<p>Document and Applicants Reference (Examination Library Reference)</p>	<p>Comment</p>
<p>Highways England – Deadline 1 Submission - 6.7 Appendix 2.1 Lighting Assessment - Rev 1 (REP1-011)</p>	<p>Noted the reasoning behind not introducing lighting throughout the route. Notwithstanding any future reconsideration that there may yet be on safety grounds, this decision is welcomed from the point of view of emerging Local Plan Policy ENV 4 regarding the maintenance of dark skies in open countryside areas, especially within the zone of influence of the Dark Sky Park and the AONBs. Should there be any reconsideration of the lighting issue, any lighting introduced should follow lighting design guidance referred to in Policy ENV 4.</p>
<p>Highways England – Deadline 1 Submission - 6.22 Noise Addendum - Rev 0 (REP1-019)</p>	<p>In Table 1-4 – Local Planning Policy Relevant to Noise, the relevant Local Plan and Core Strategy policies seem to be satisfactorily addressed.</p>

<p>Highways England – Deadline 1 Submission - 7.8 Applicant’s Response to ExA’s First Written Questions - Rev 0 (REP1-032)</p>	<p>GEN1.8 We consider that the introduction of a footway/cycleway along the full length of the

highways  
england

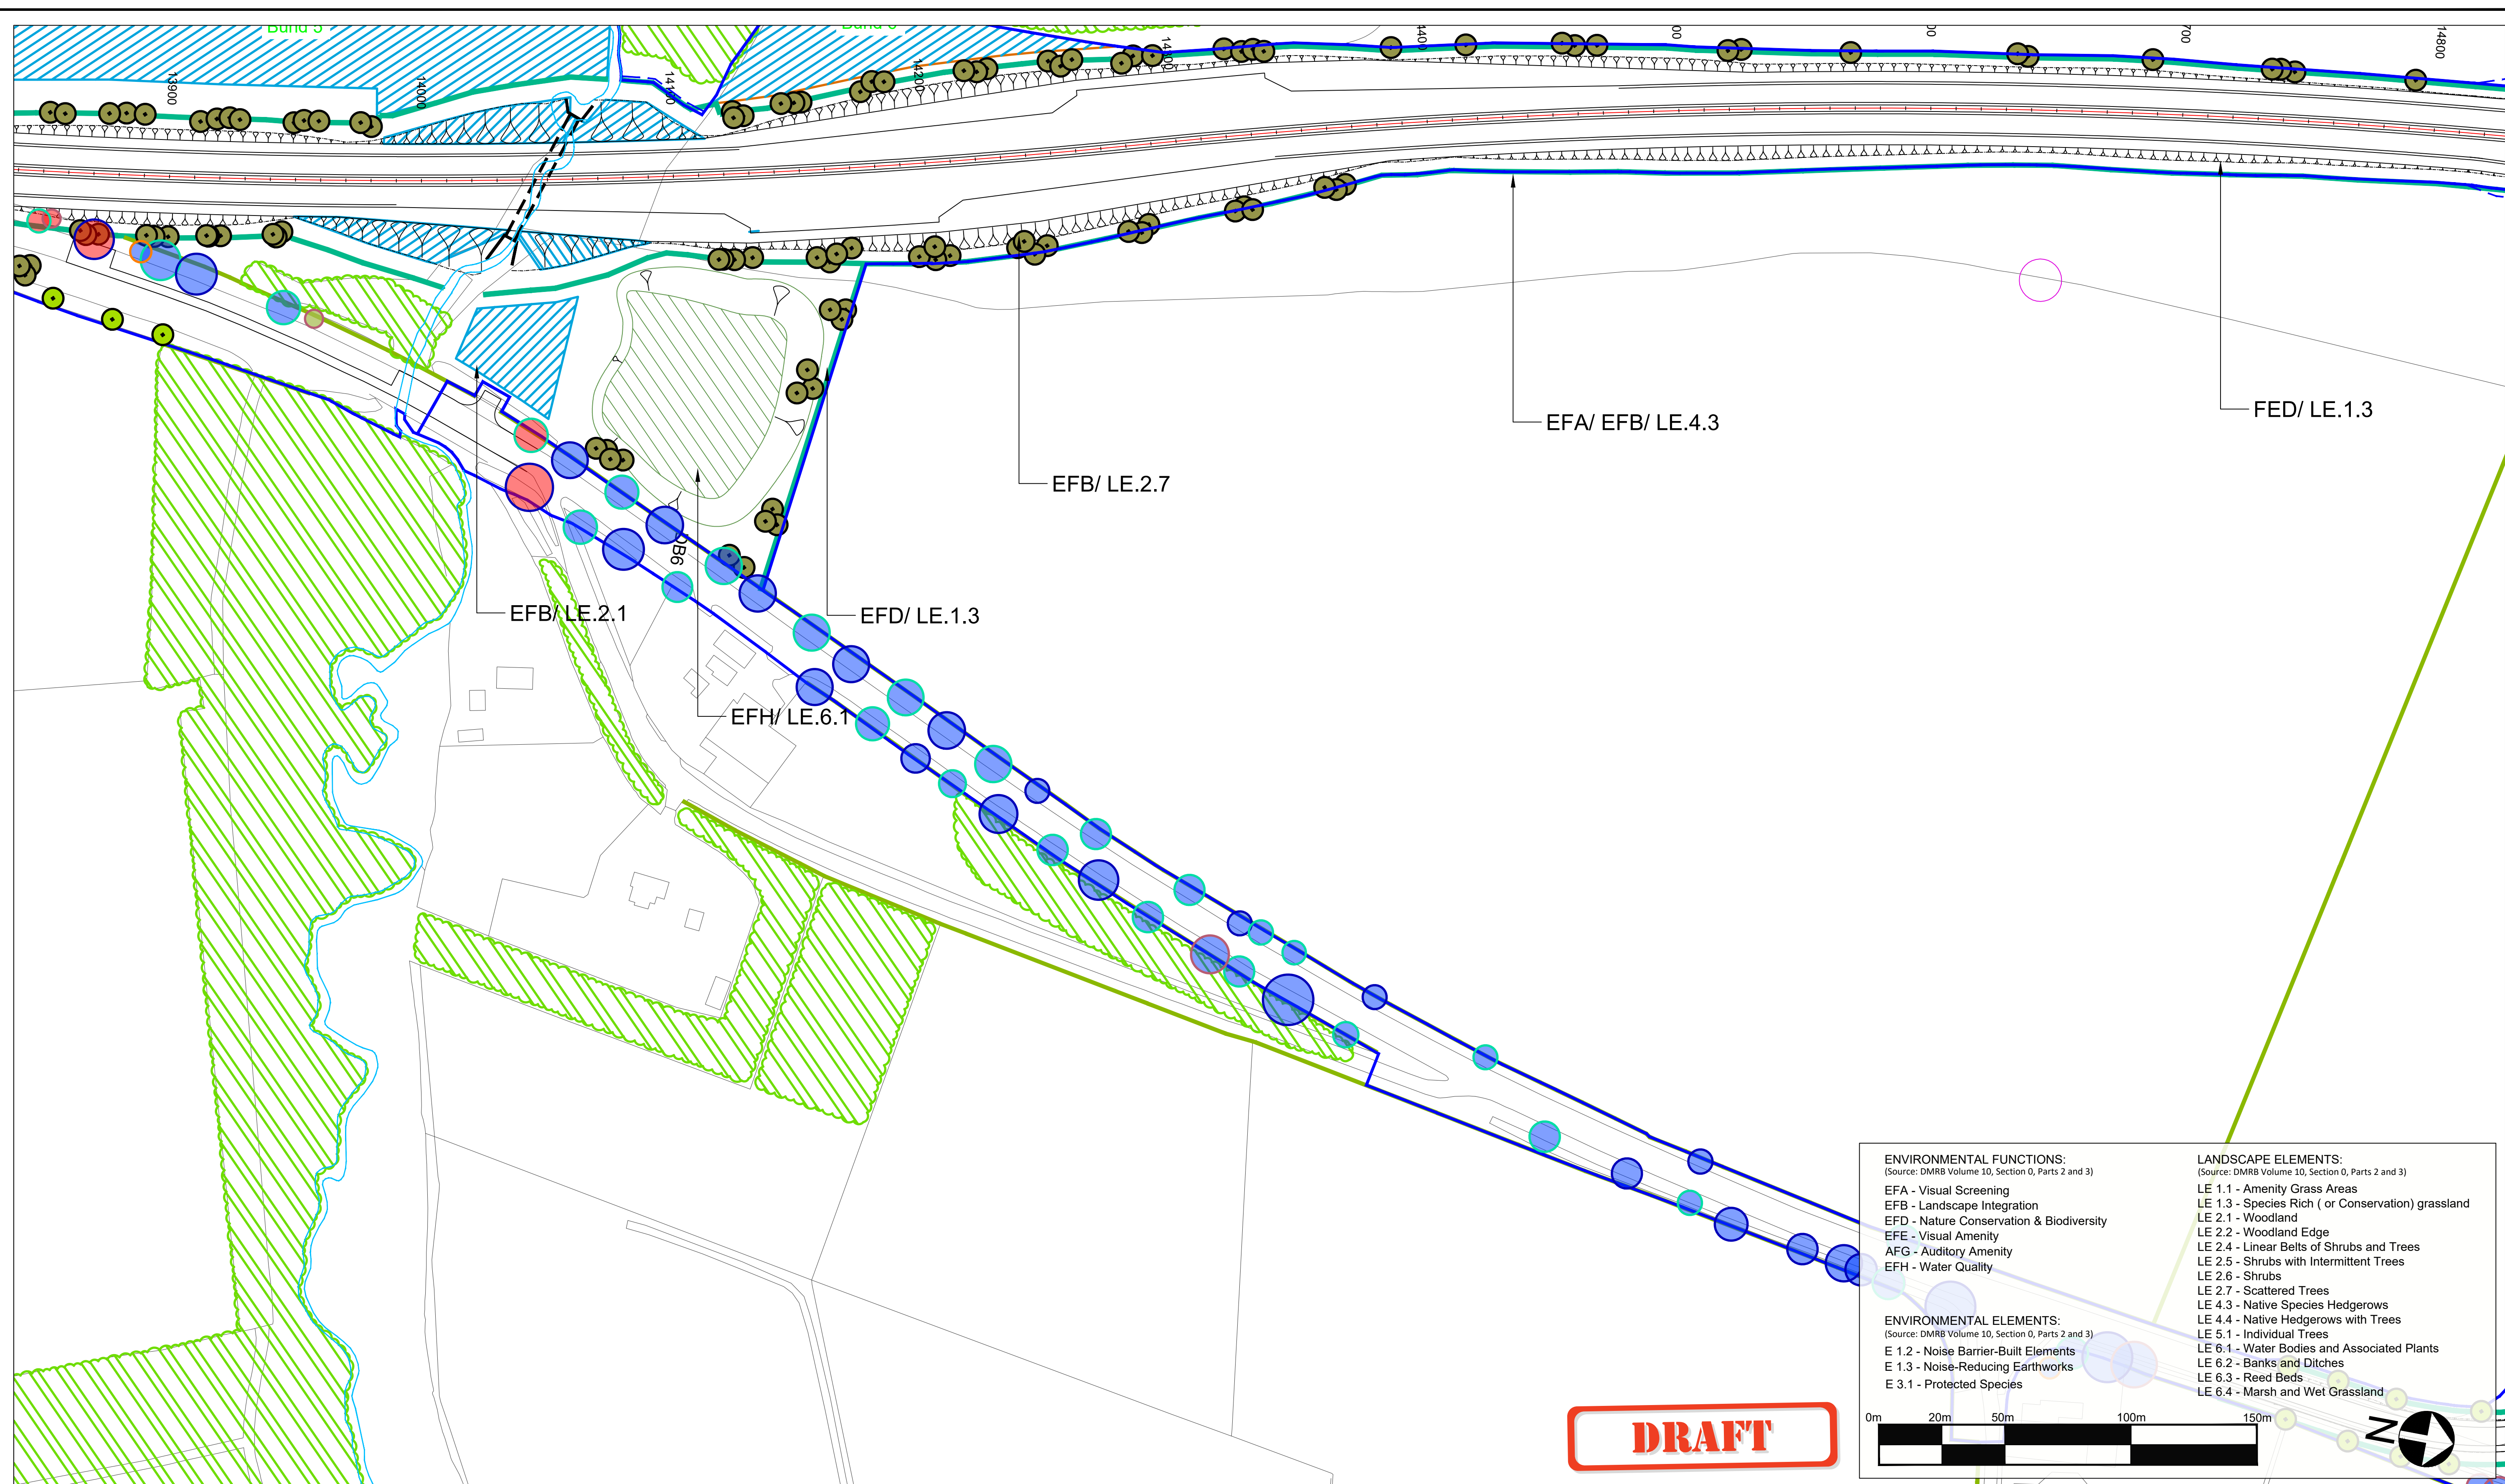
Document and Applicants Reference (Examination Library Reference)	Comment
Highways England – Deadline 1 Submission - 7.8.13 Appendix LV.2 Trees to be removed and replaced at Coronation Avenue (REP1-044)	As previously reviewed and agreed
Highways England – Deadline 1 Submission - 7.8.20 Appendix LV.1 Summary Table (REP1-050)	The schedule of vegetation removals has not been reviewed in detail. Will be discussed with applicant as part of Statement of Common Ground discussions.
Highways England – Deadline 1 Submission -7.8.21 Appendix LV.3 response to WQ LV 1.1.13 (REP1-051)	This document provides a specific response regarding potential further mitigation for significant effects on residential receptors. Several of these coincide with community receptors at West Moor (R35, R36 and R37) and Causey Park Bridge (R58 and R59) for which we have been requesting further consideration and mitigation (see above) and still consider despite the response given that improvements to mitigation could be made. Discussions with the applicant are ongoing on this matter
